CITY OF ALBUQUERQUE

RE: **Casitas de Colores** – Grading & Drainage Plan for Work Order & Building Permit
215 Lead Ave. S.W. P.E. Stamp: 09/04/12 (**K14-D087A**)

Based upon the information provided in your submittal received 9-6-2012, the above referenced plan cannot be approved for Work Order or Building Permit until the following comments are addressed:

**ISAACSON & ARFMAN, P.A.**  
Consulting Engineering Associates  
128 Monroe Street N.E.  
Albuquerque, New Mexico 87108  
Ph. 505-268-8828 www.iacivil.com  
1925 CG-501.dwg Oct 23, 2012

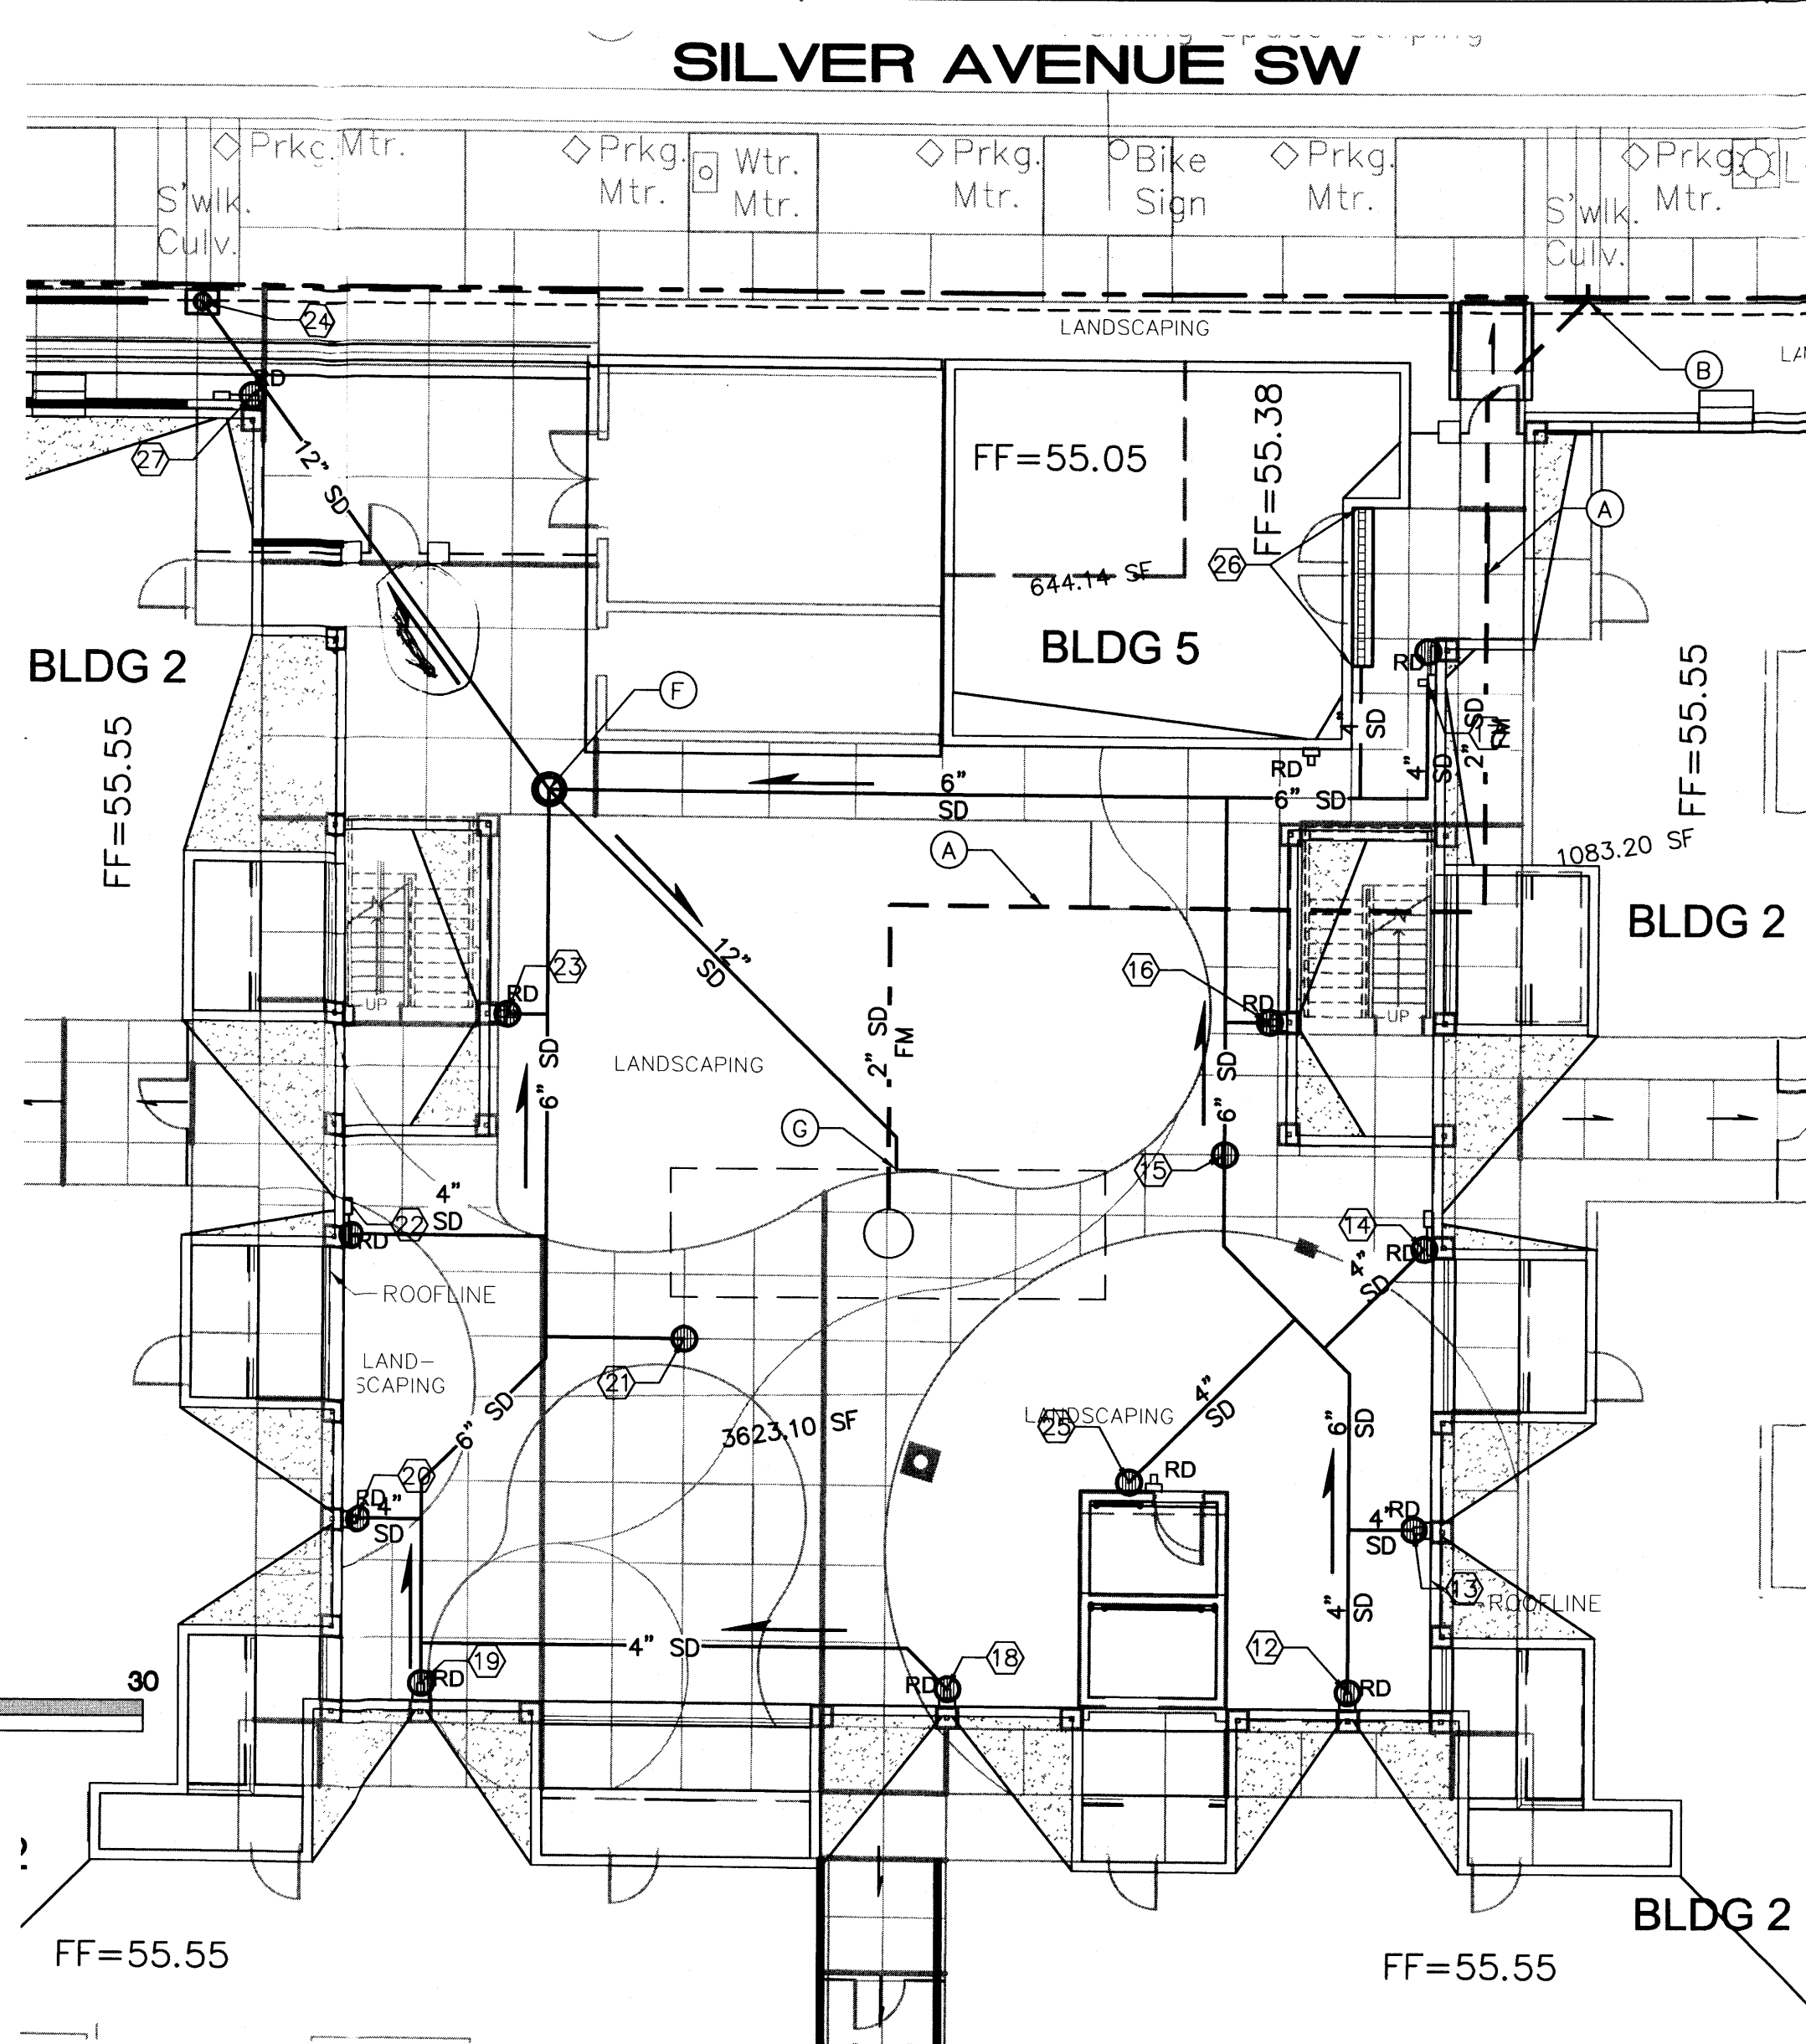
6. **CG-501:** On Details 1 & 2, what is the depth of material in the swales?
7. **CG-501:** The "Pipe Through Walk" Detail does not address 2-4" pipes shown on plans.

8. **CG-501:** Provide missing details referred to on plans.
 - a. **"Turn-Down Sidewalk Edge"** detail referred to on CG-102. (and correct the reference page to CG-501, in Note 4 on CG-102).

**CG-502**

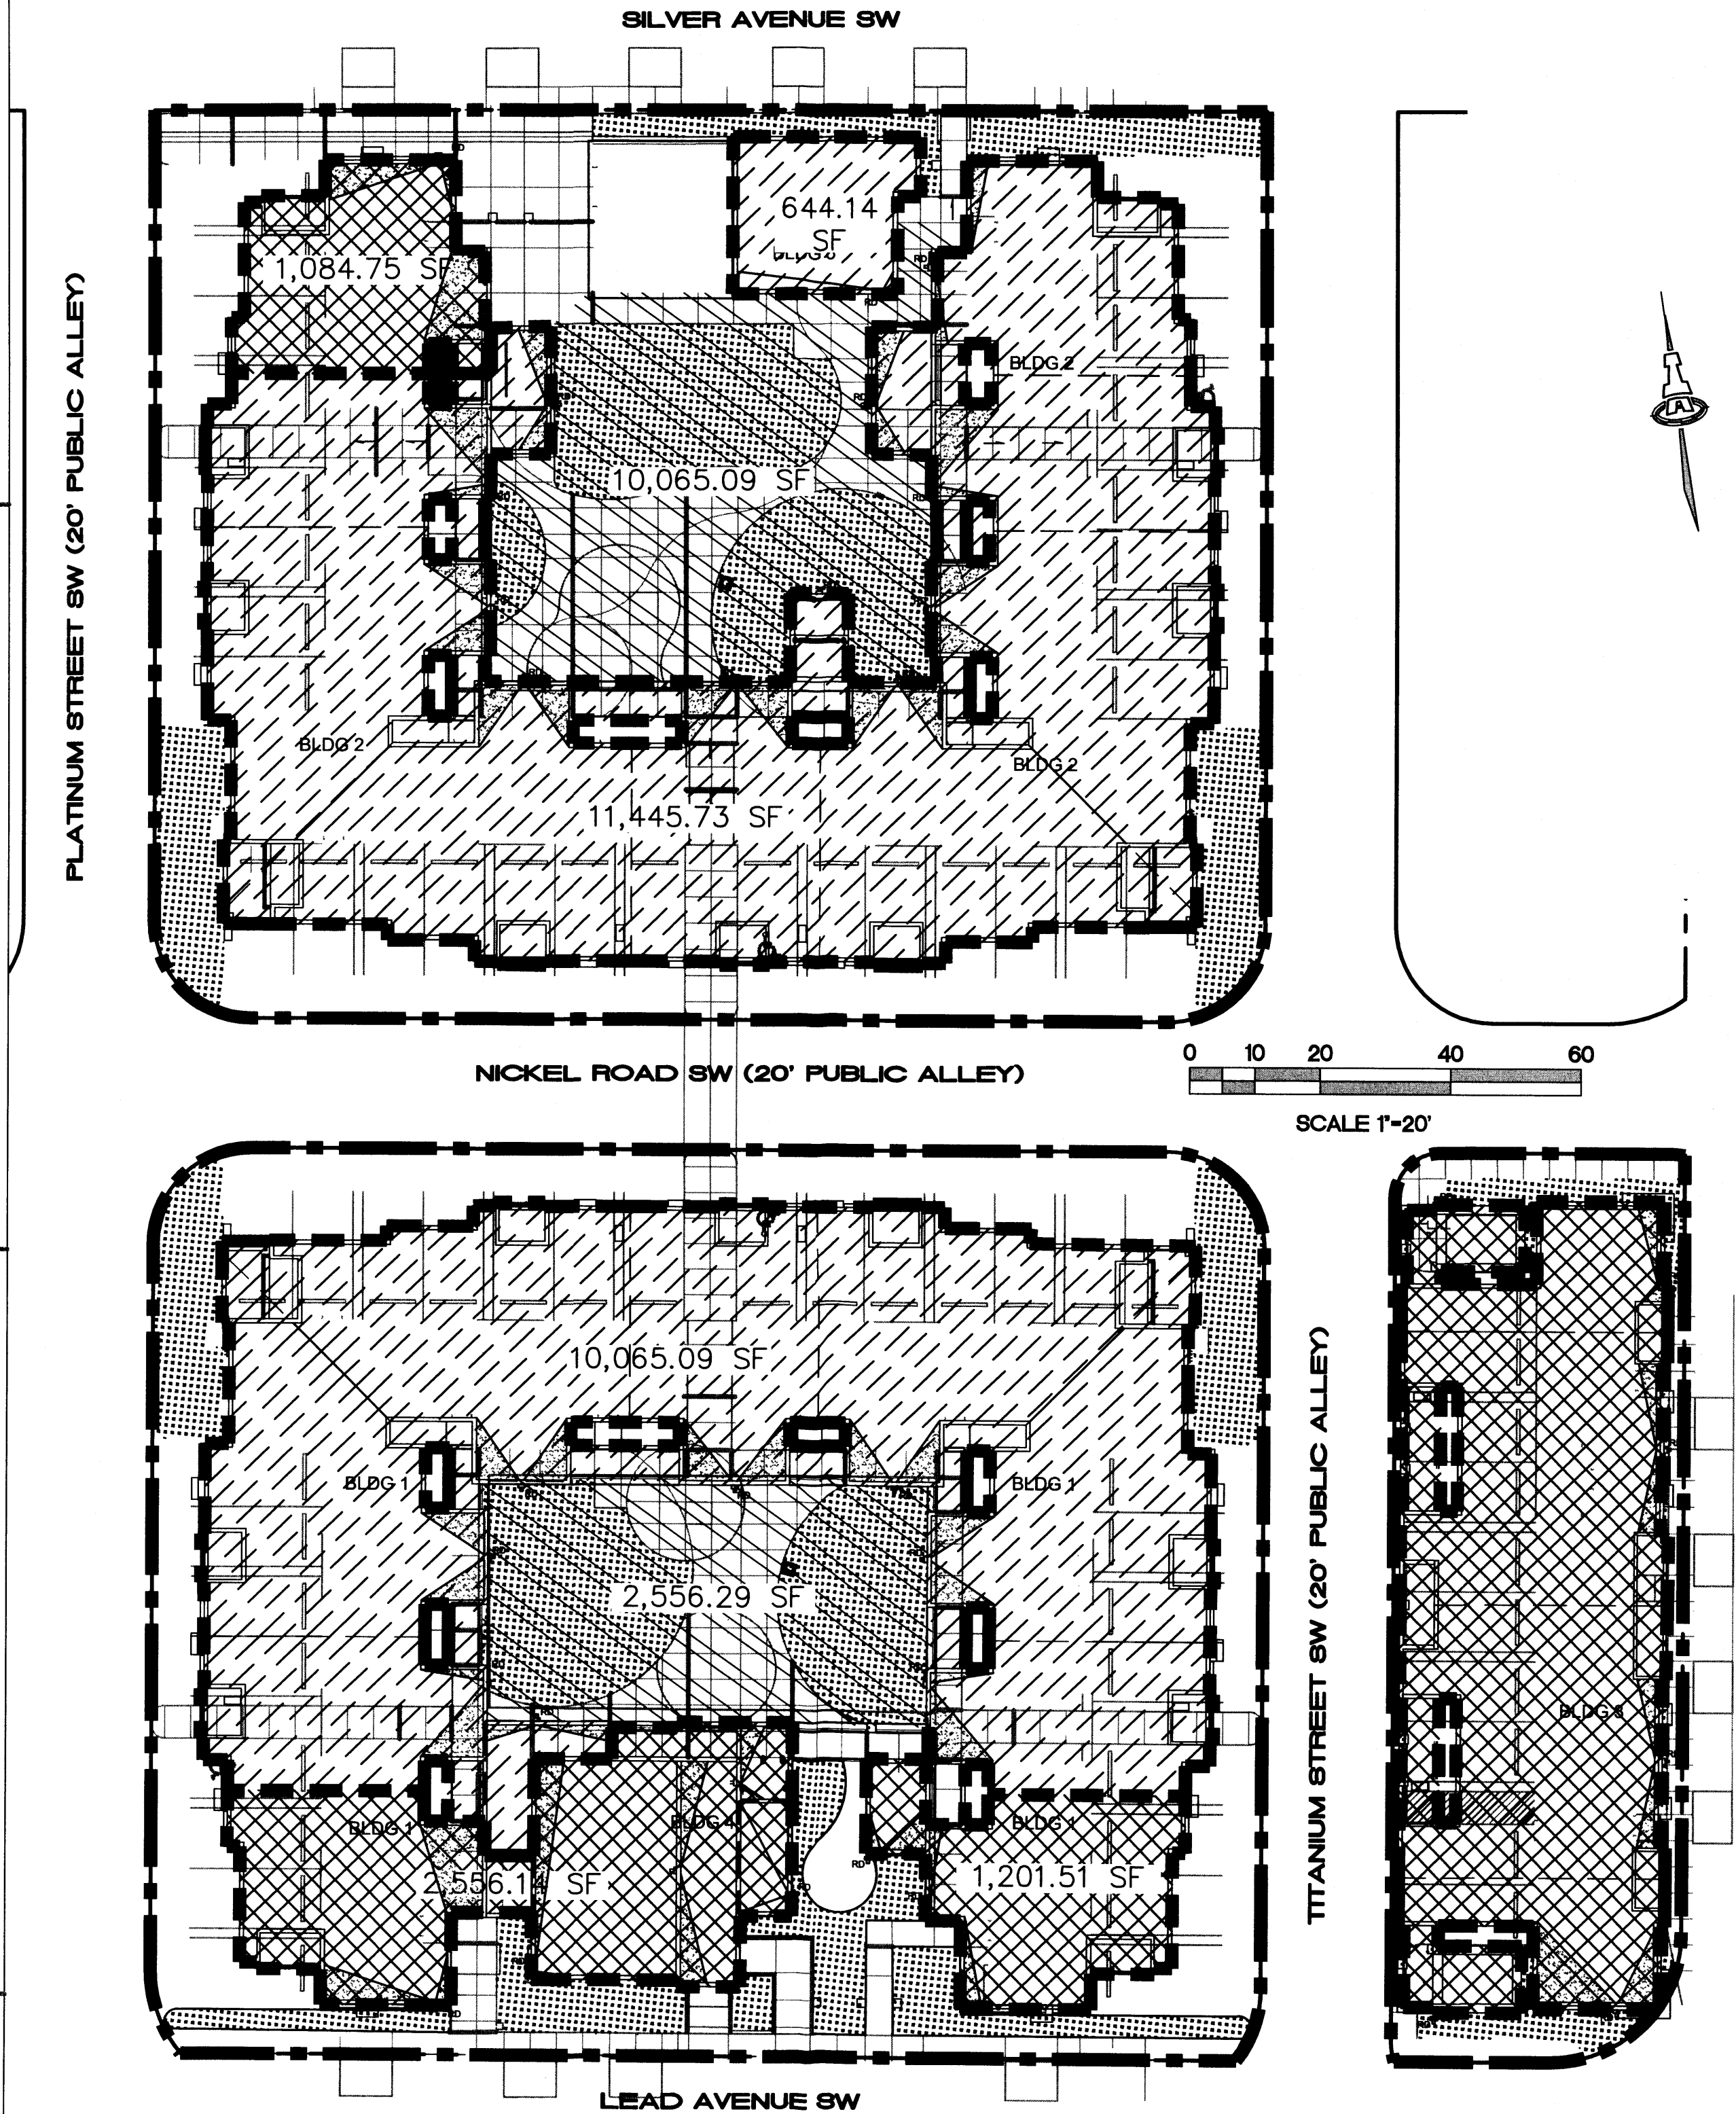
1. Provide a drainage basin map corresponding to calculations provided. Label surface treatments there, or on the plan sheets to verify runoff rates. The Basin Table and calculations provided appear to meet the agreed criteria, however, I do need the basin map and roof drain, discharge points to verify acceptability.

- b. **“Header Curb”** detail referred to on CG-101 & 102.
9. **CG-502 & 503:** Provide flow direction arrows by main pipes in the drainage system.
10. **CG-502 & 503:** Water standing in the overflow pipes from the water treatment manholes may become maintenance and insect-breeding problems. These lines should be designed to drain back to the cisterns.
11. **CG-502 & 503:** Sheets lack North Arrows and Scales associate with the plans. Also, label Lead Ave & Silver Ave. for clarity.
12. **CG-502:** Storm Drain General Not 8 recommends monthly maintenance of the system. This or sheet CG-504 should at least outline the level of maintenance to expect, so that owner and later operator understands the importance of this maintenance.
